7 September 2021

**Customer Fulfilment Centre and Warehouse, Marrickville (SSD-10468)
Request for Additional Information**

10 CONTROL OF CONSTRUCTION NOISE AND VIBRATION – PROCEDURAL STEPS

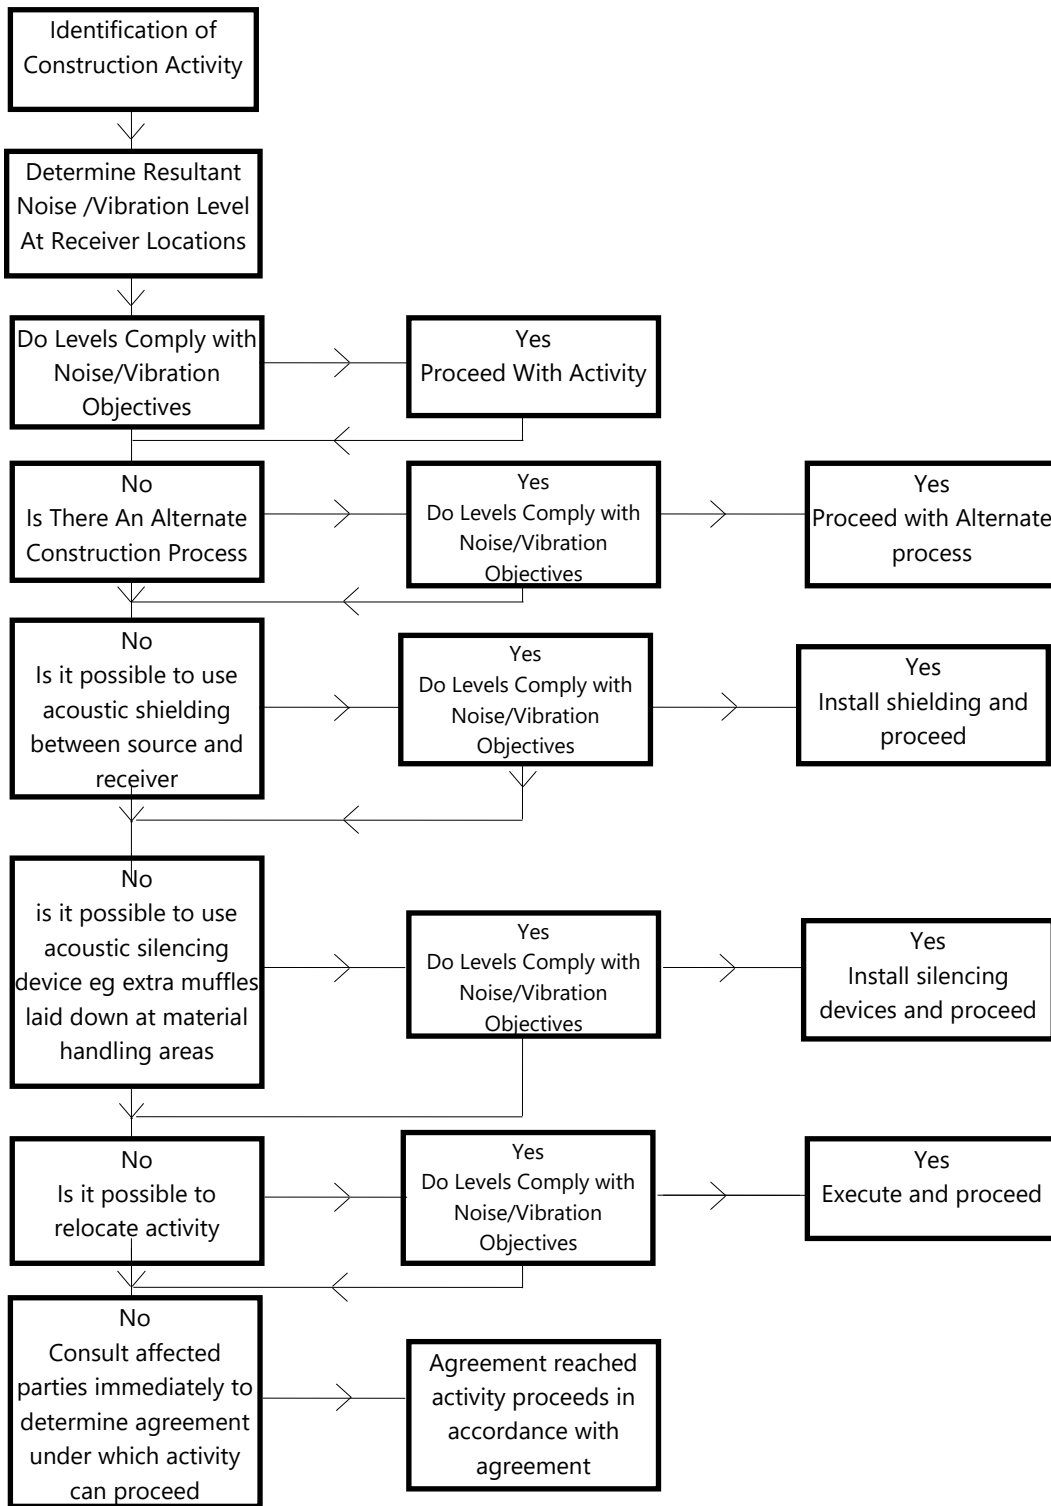
- the Department notes that Section 10 includes a comprehensive flowchart illustrating the process which would be followed by the Applicant when implementing construction noise mitigation measures. Please confirm the Applicant is supportive of this flowchart, given the mitigation process proposed is more commonly used for infrastructure projects, rather than industrial projects.
